I-85 GASTON COUNTY WEIGH STATION BUILDINGS

TIP No. I-4928
Project No. WBS 41188.3.1

Date: 02/12/14
Project: I-4928: I-85 NBL Weigh Station
Gaston County NC
RE: Addendum # 2
Building Utilities

1 SITE PLAN
U2 SCALE: 1'-0"=10'-0"

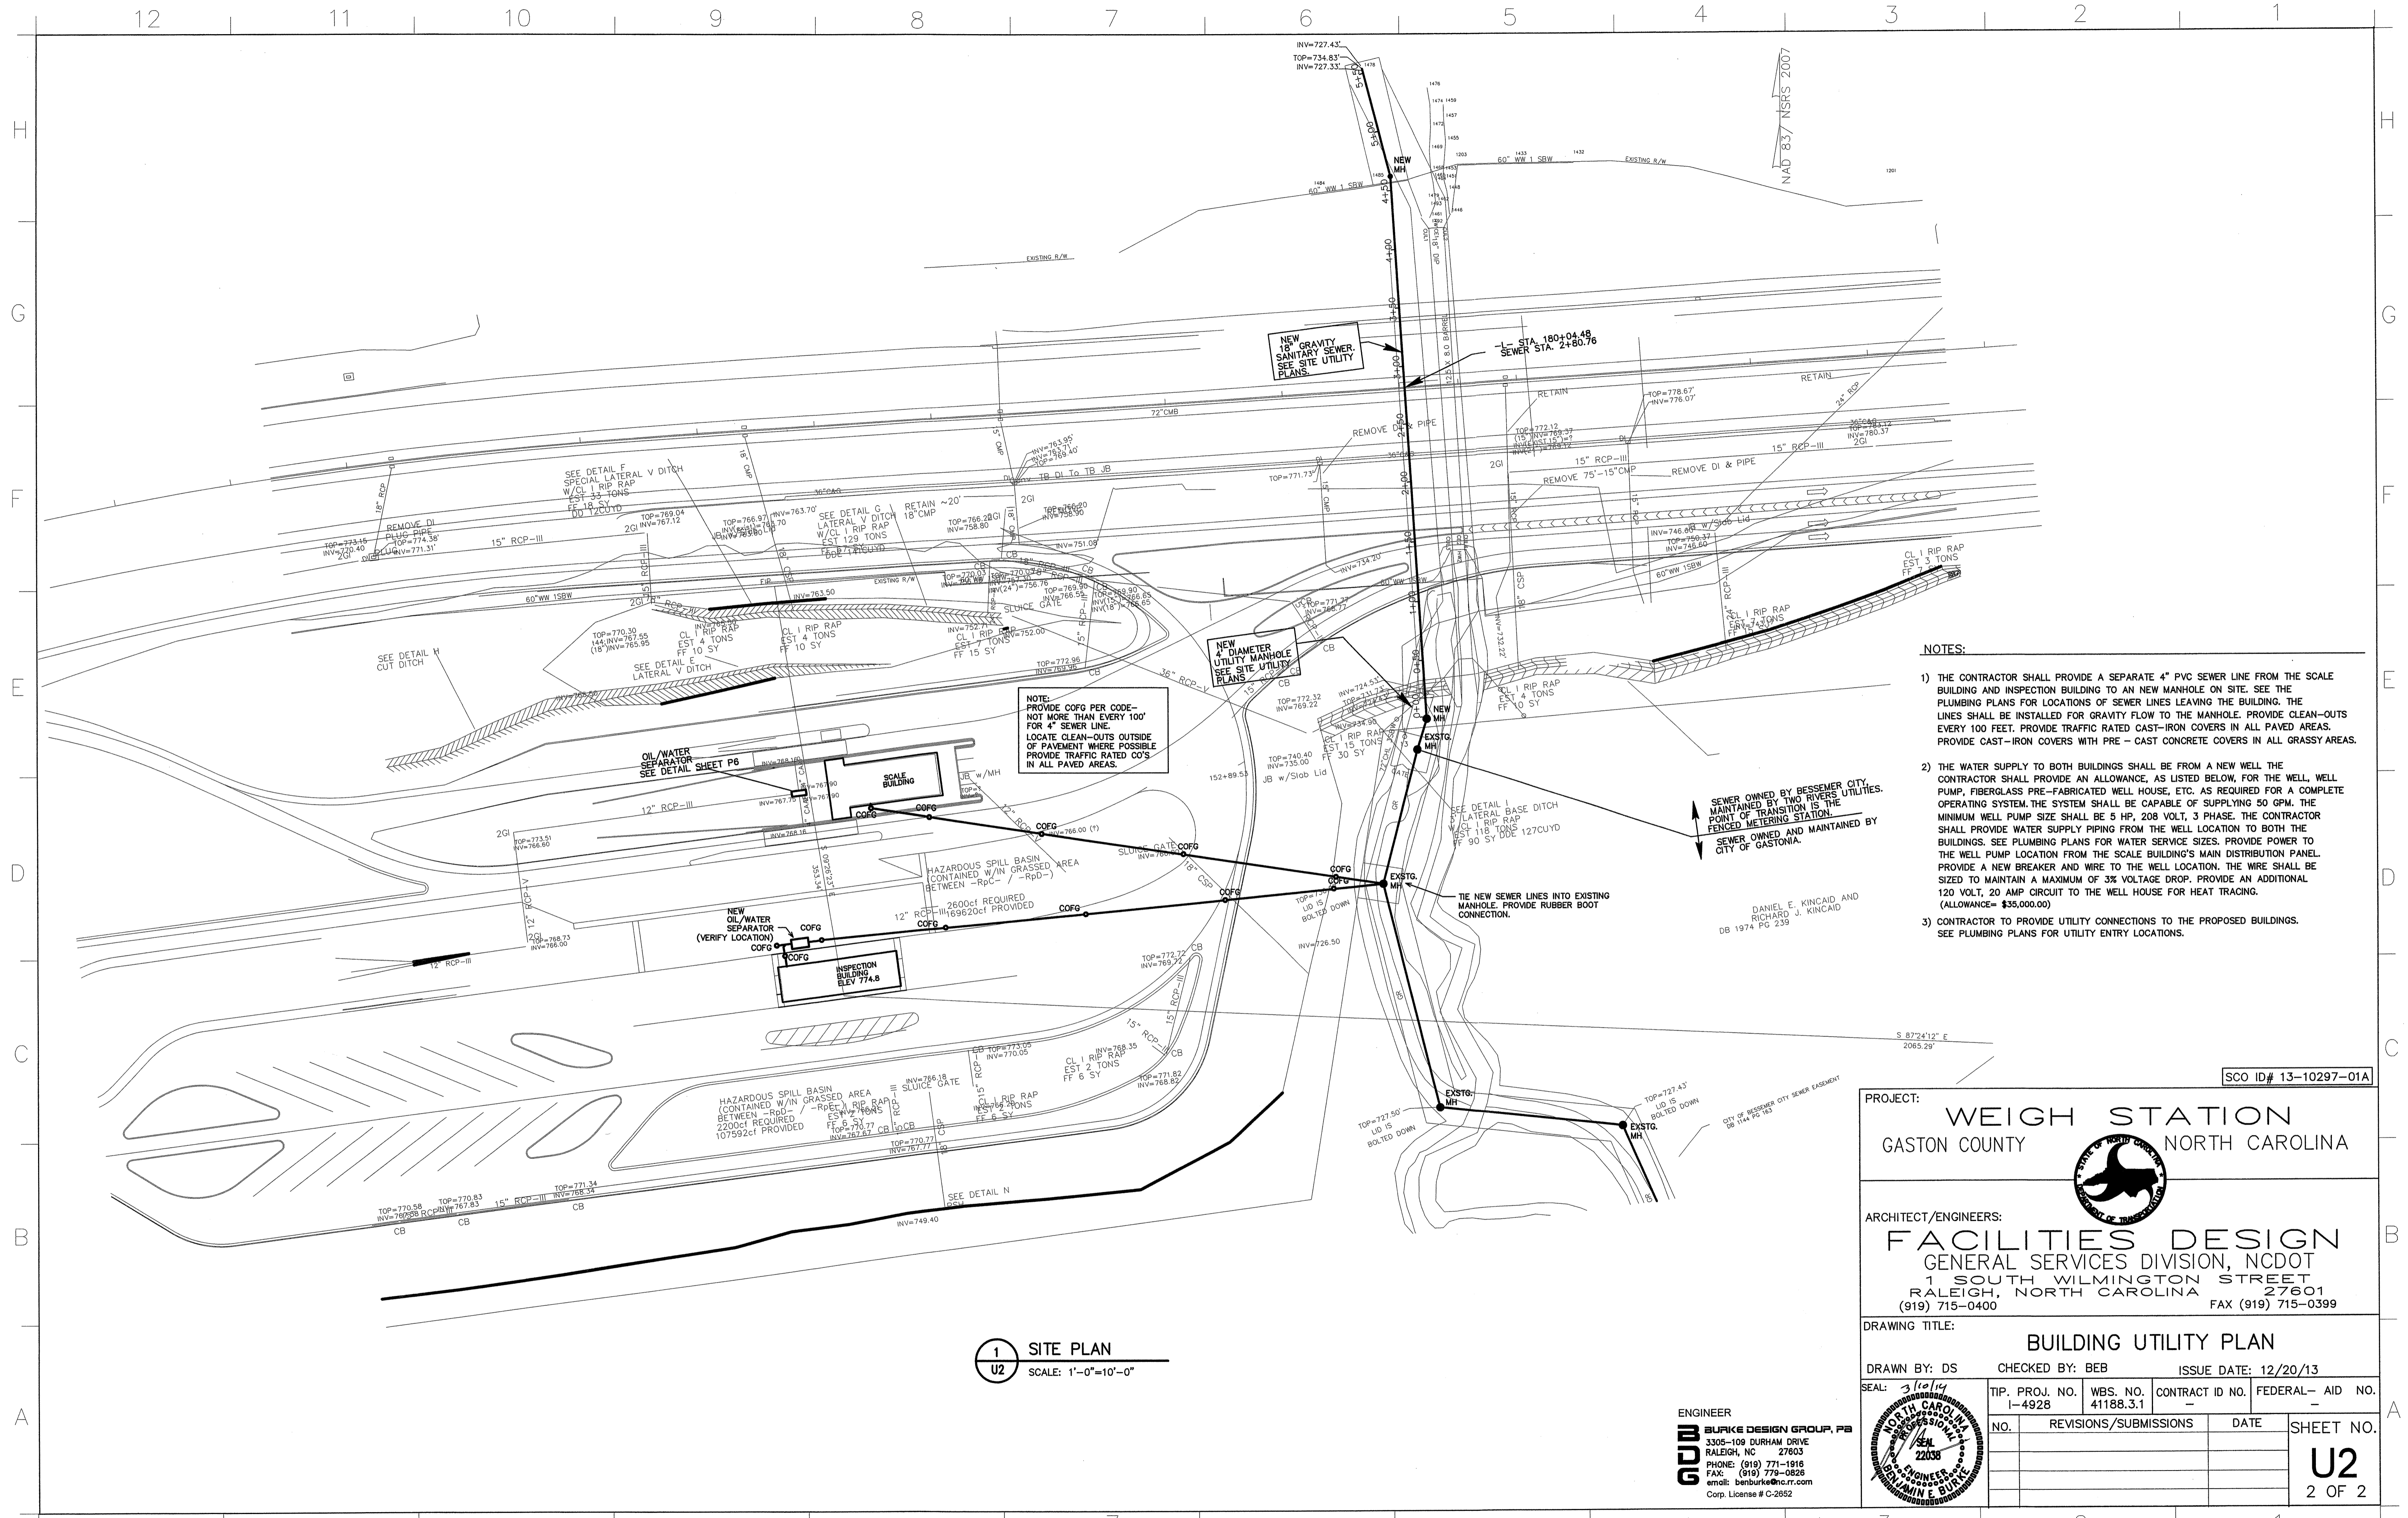
- 1) The contractor shall provide a separate 4" PVC sewer line from the Scale Building and Inspection Building to an existing manhole on site. See plumbing plans for locations of sewer lines leaving the building. The manhole is due west from the building locations. The elevation of the top of the man-hole is 730.07'. The manhole is located approximately 400 feet from the Scale Building and 480 feet from the Inspection Building. The lines shall be installed for gravity flow to the manhole. Provide clean-outs every 100 feet. Provide traffic rated cast-iron covers in all paved areas. Provide cast-iron covers with pre-cast concrete covers in all grassy areas.

- 2) The water supply to both buildings shall be from a new well. The contractor shall provide an allowance, as listed below, for the well, well pump, fiberglass pre-fabricated well house, etc. as required for a complete operating system. The system shall be capable of supplying 50 gpm. The minimum well pump size shall be 5 hp, 208 volt, 3 phase. The contractor shall provide water supply piping from the well location to both the buildings. See plumbing plans for water service sizes. Provide power to the well pump location from the Scale Building's main distribution panel. Provide a new breaker and wire to the well location. The wire shall be sized to maintain a maximum of 3% voltage drop. Provide an additional 120 volt, 20 amp circuit to the well house for heat tracing.
